Our Ref: CM/33/18/PL

**Town & Country Planning Act 1990 (as amended)
Town and Country Planning (Development Management Procedure) (England) Order 2015
Application for Planning Permission**

Development Replacement dwelling
Location Waysmeet Cottage Grevatts Lane Climping

Site & Floor Plans_Proposed
Dwg. No. 597-104

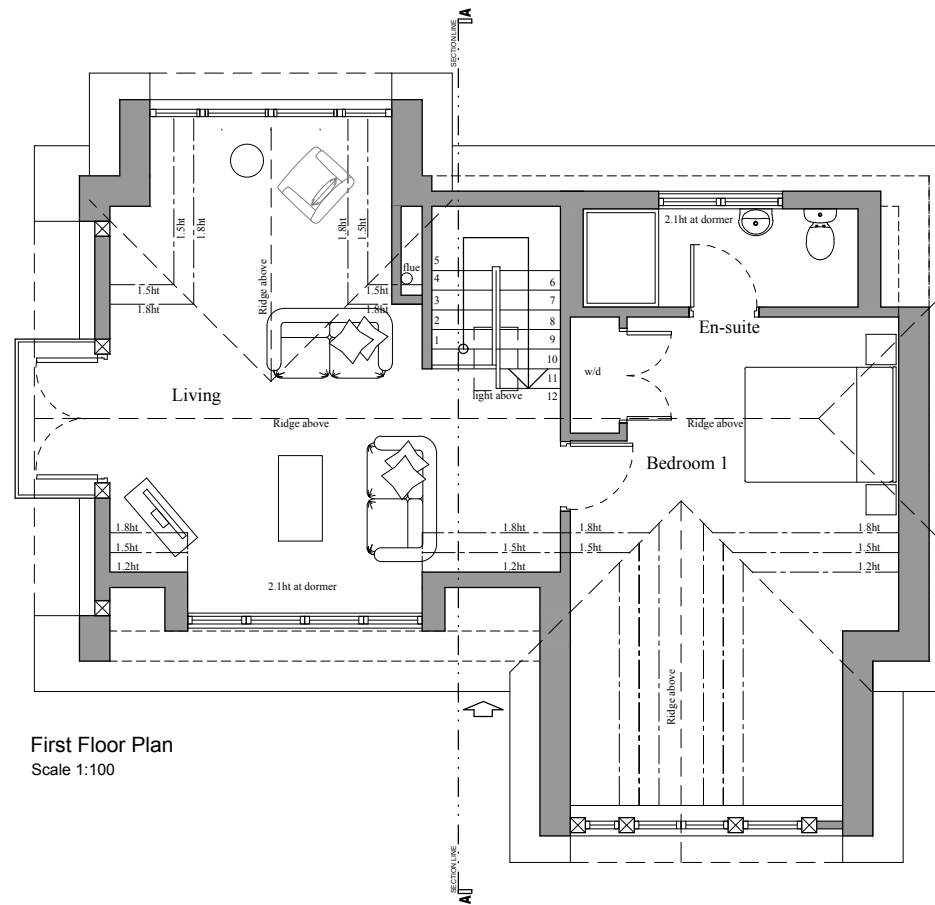
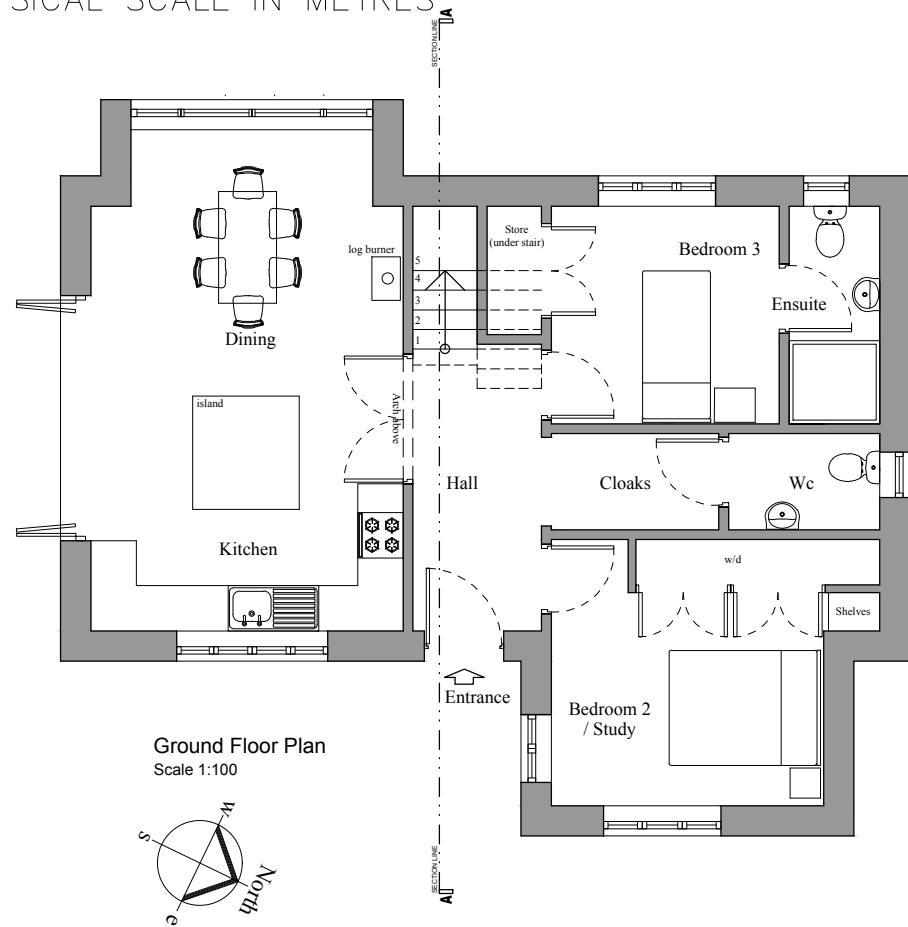
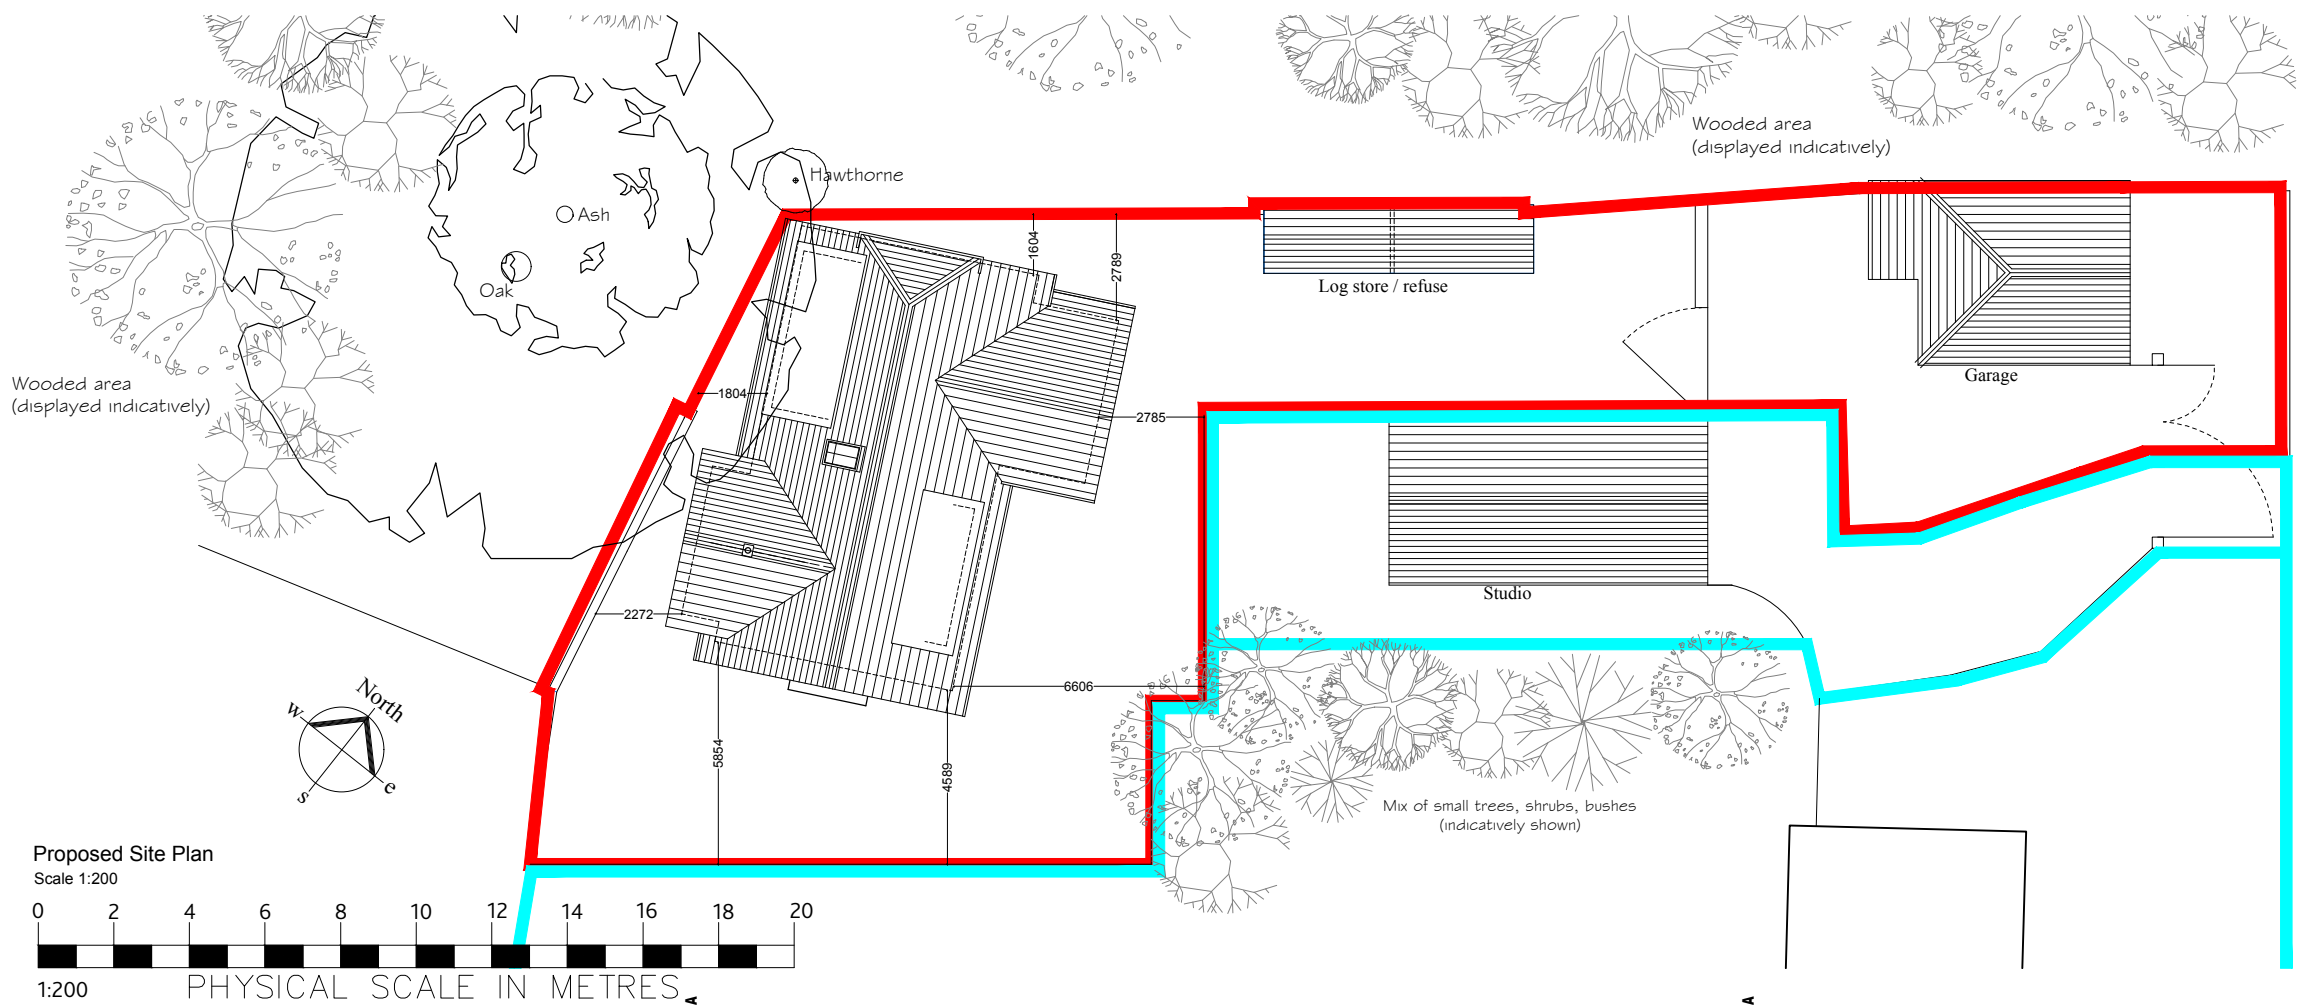
Block Plan

Please annotate the dimensions from the proposed new dwelling to all site boundaries.
